From: [Mau, Russell E \(DOH\)](#)
To: [Rachael Stevie \(CD\)](#)
Cc: [Smits, Brenda M \(DOH\)](#); [Holly Erdman](#); [Hayden, Kathryn E \(DOH\)](#); [DOH EPH DW ERO ADMIN](#)
Subject: RE: SE-21-00018 Anderson Hay - Notice of Application
Date: Tuesday, September 7, 2021 8:18:40 AM
Attachments: [image001.png](#)

SUBJECT: WDFW COMMENTS ON SE-21-00018 Anderson Hay

TO: Community Development Services
FROM: Public Works Plan Review Team
DATE: September 15, 2021
SUBJECT: SE-21-00018 Anderson Hay

Re: SEPA Register 202104866, SE-21-00018

MTA HOLDINGS TOPOGRAPHIC SURVEY
 PART OF THE SOUTHWEST QUARTER OF SECTION 22,
 TOWNSHIP 17 NORTH, RANGE 18 EAST, W.M.

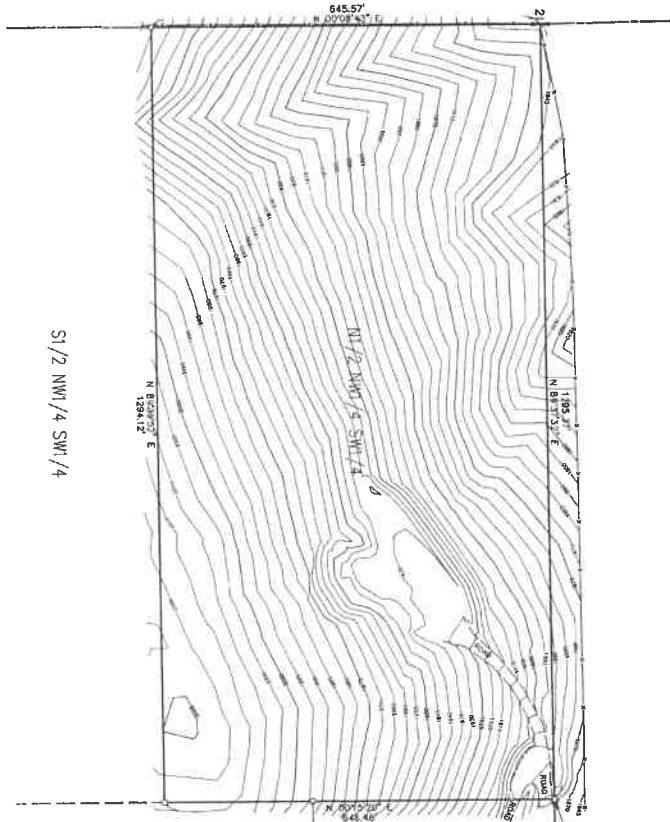
- Fire apparatus access roads exceeding 150' shall be provided with a temporary or permanent turnaround meeting the requirement 2018 IFC Appendix D.
- Fire apparatus access roads shall not exceed 10% in grade. This is especially critical in our valley's climate. Based on the provided information there are portions of the proposed road that exceed 10%.
- The IFC requires the road be capable of supporting an imposed load of at least 75,000 lbs.
- Our standard turning radius is a minimum of 23' inside and 45' outside.
